Our Ref: FP/201/18/PL

**Town & Country Planning Act 1990 (as amended)
Town and Country Planning (Development Management Procedure) (England) Order 2015
Application for Planning Permission**

Development 1 No. dwelling.
Location Mermaid And Playbox Sea Road Felpham

BLOCK PLAN

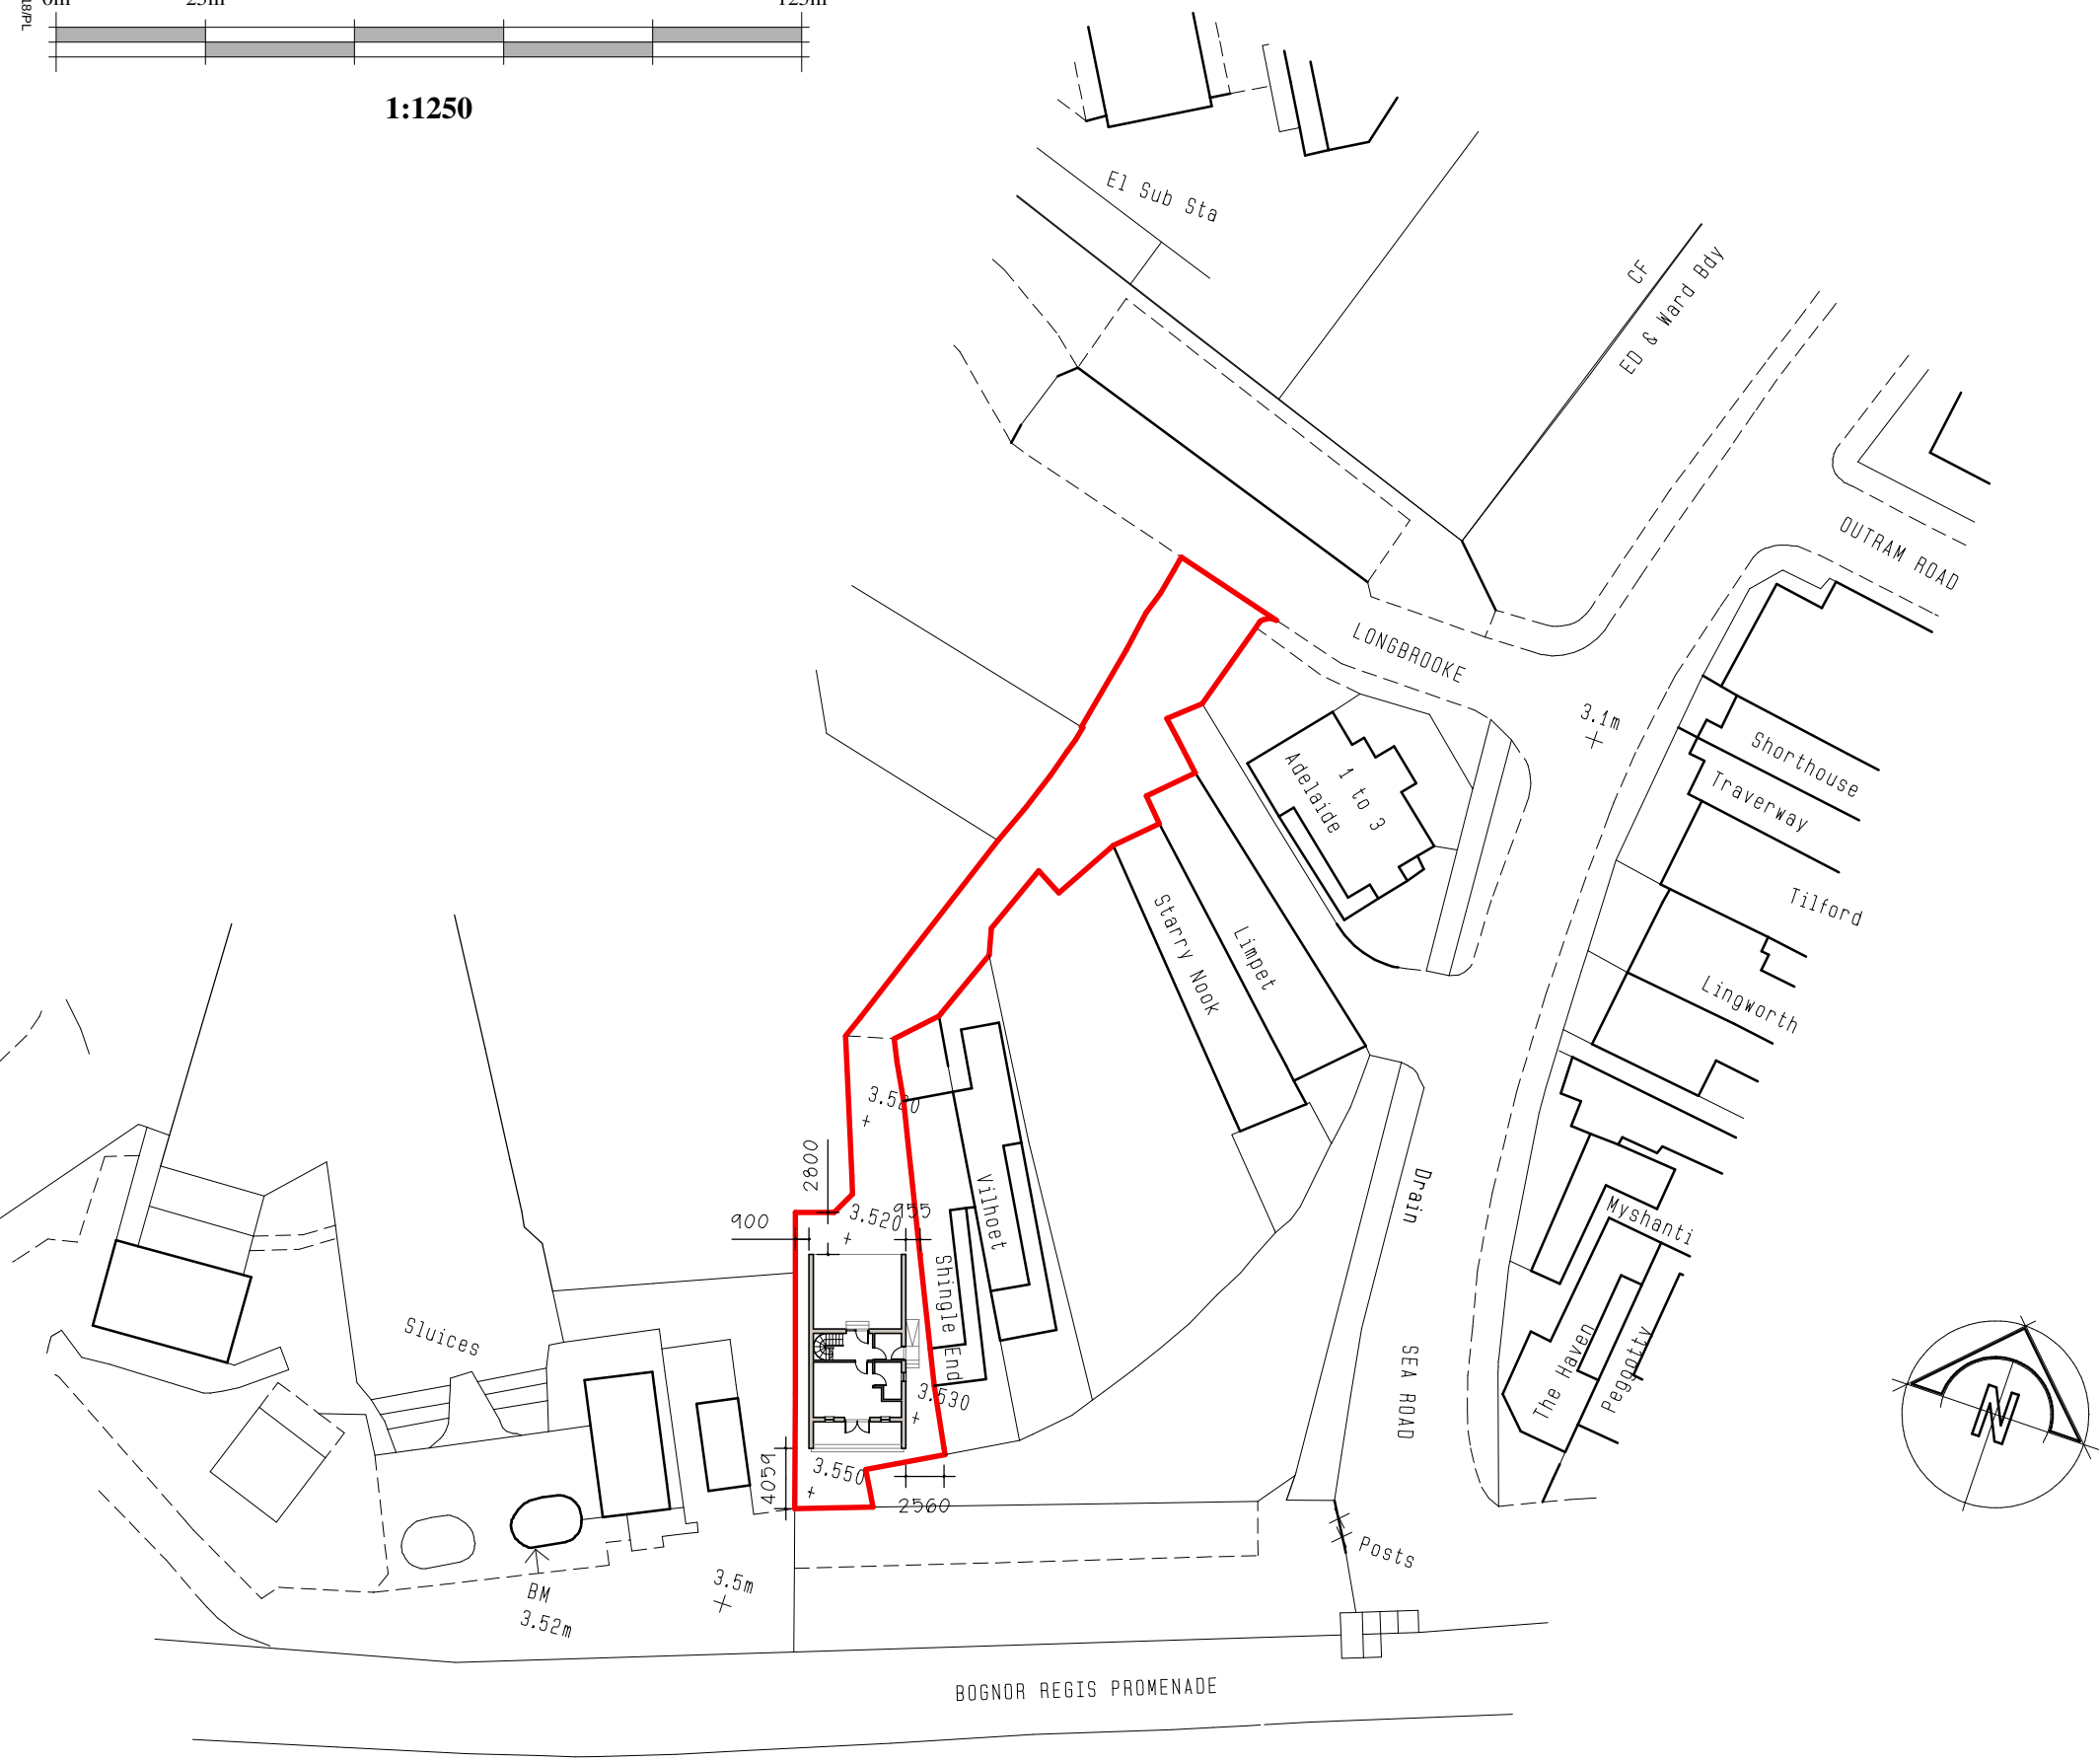
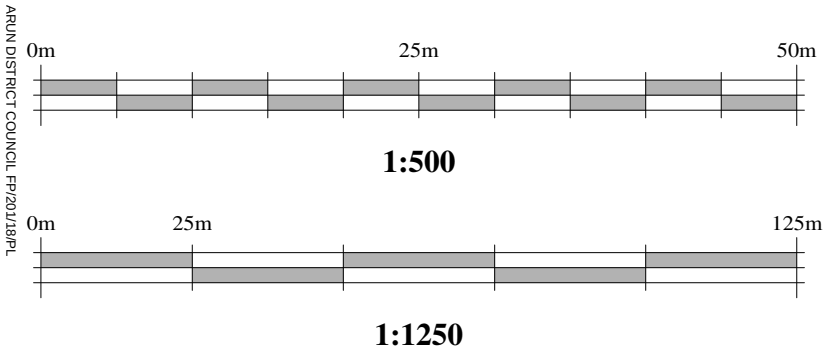
Block Plan Amend

Please provide measurements from the proposal to the site boundaries.
